CITY OF ALBUQUERQUE

November 13, 2025

**RE: Arby's Restaurant
6110 San Mateo NE
Grading and Drainage Plans
Engineer's Stamp Date: 10/16/25
Hydrology File: E18D065
Case # HYDR-2025-00399**

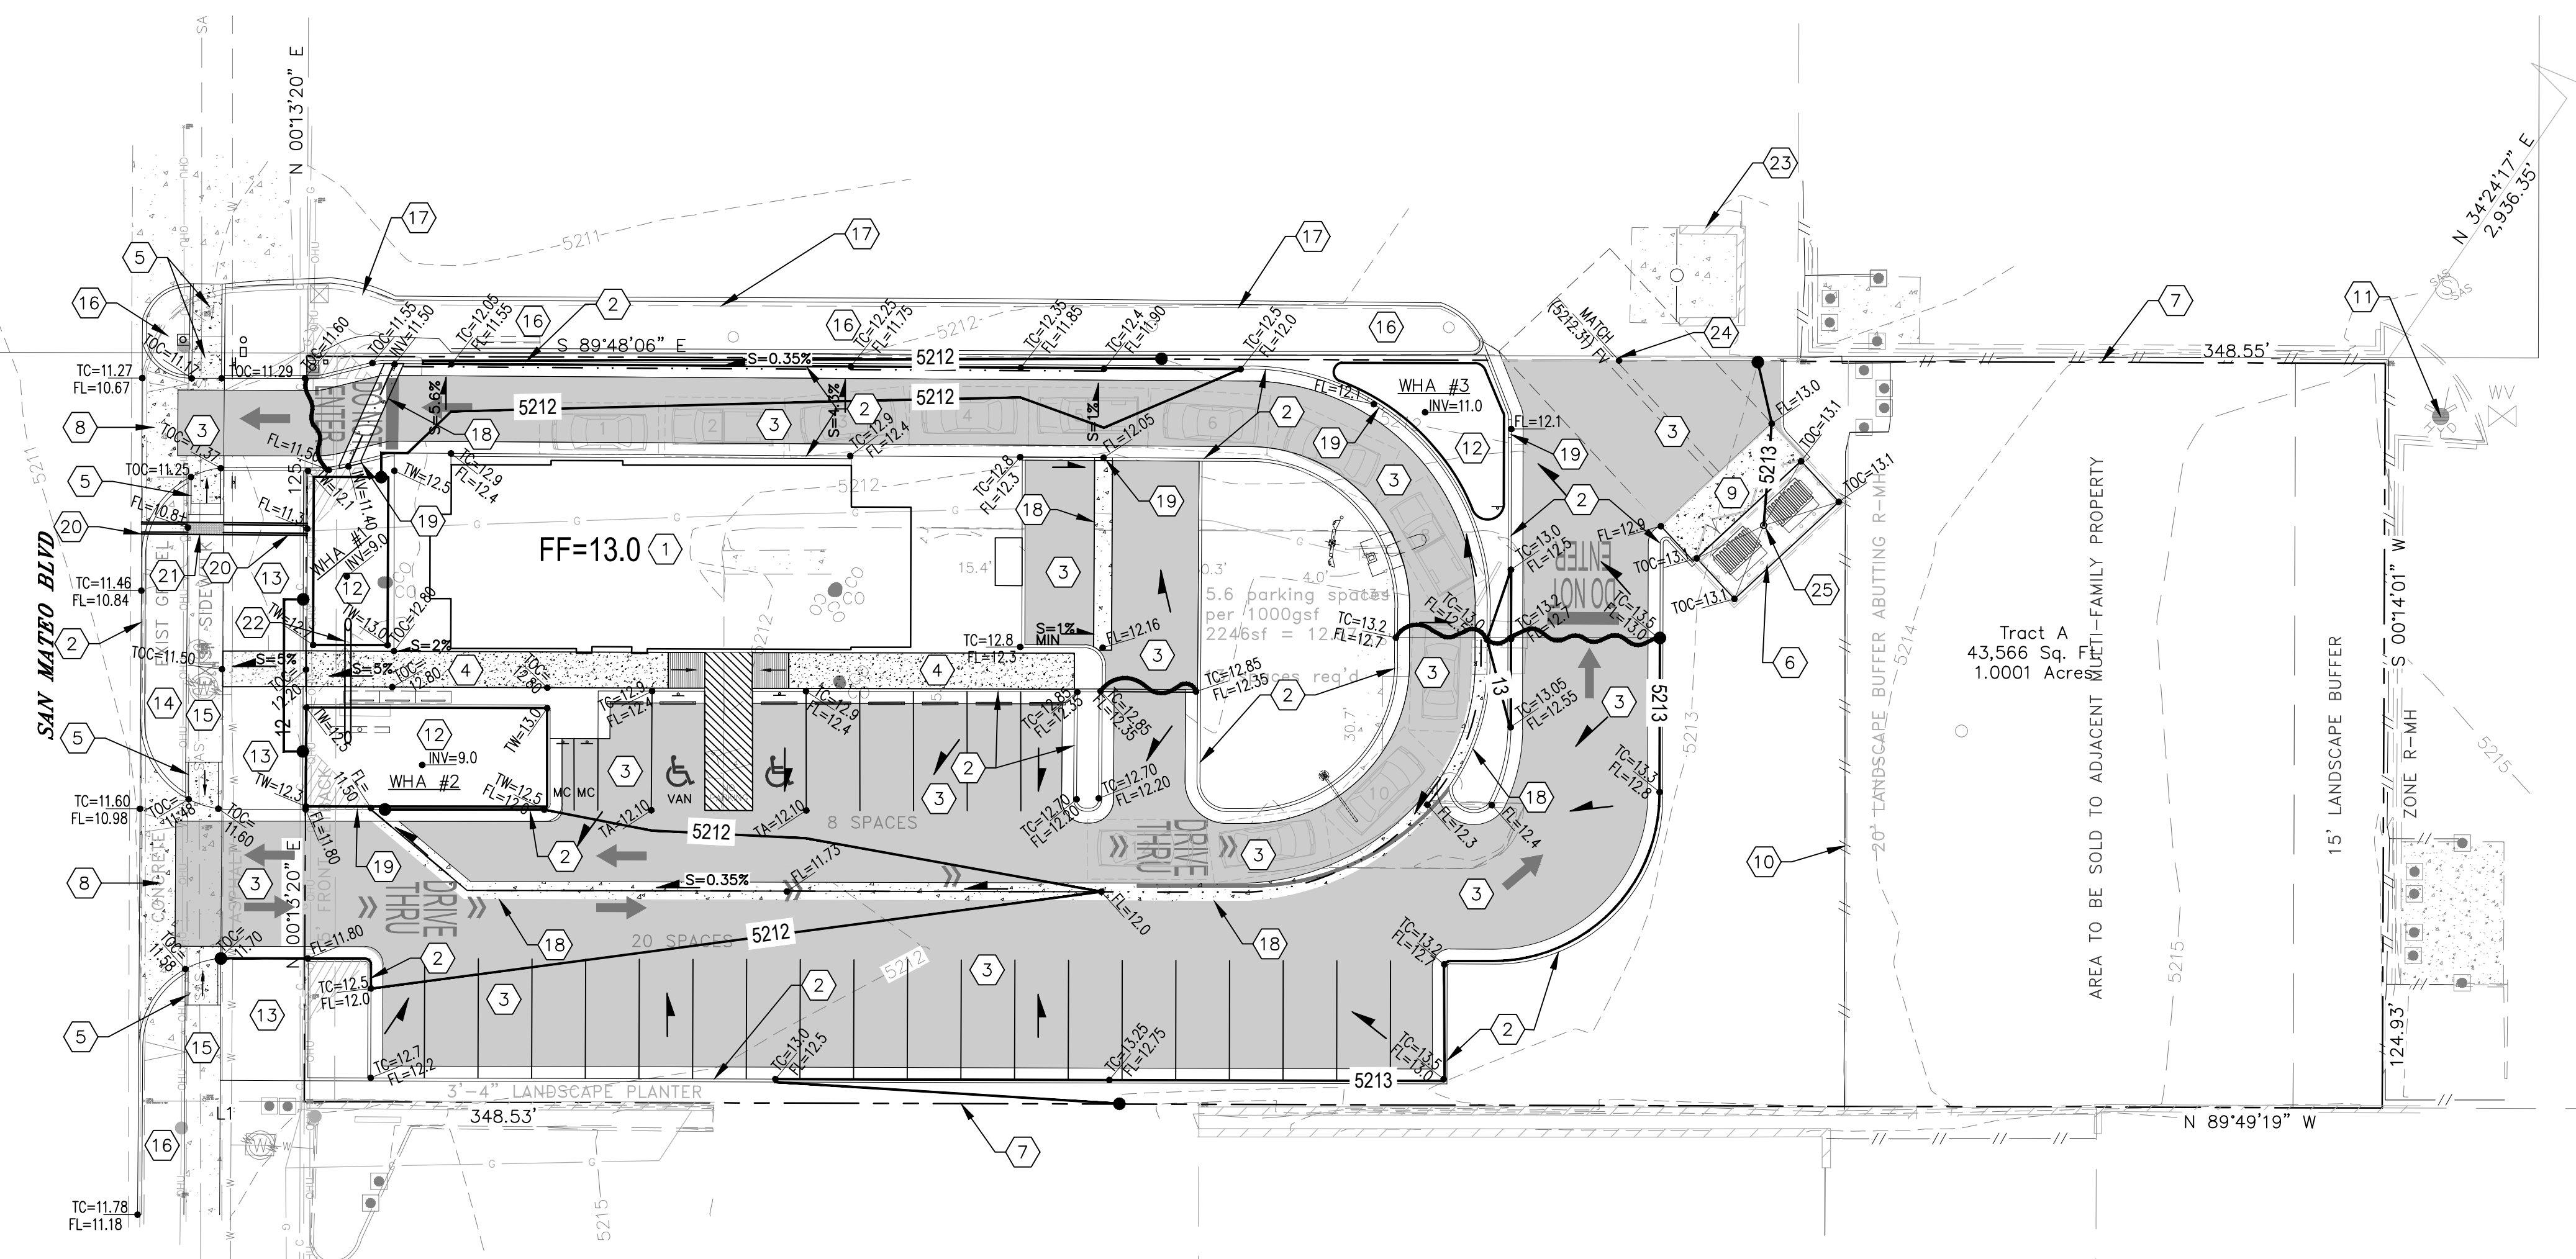
1. An SO-19 Permit will be required and should be included on the request. Please include the [standard SO-19](#) notes on the grading plan.
2. Please provide the Benchmark information (location, description and elevation) for the survey contour information provided.
3. For trash enclosures serving food service developments, trash enclosures must demonstrate control of liquids from dumpster areas per DPM by containing runoff from the dumpster area, preventing outside drainage from entering the dumpster area, and discharging to the sanitary sewer. Please show an inlet in the middle and label. "Inlet to be connected to the sanitary sewer. See Utility Plan."
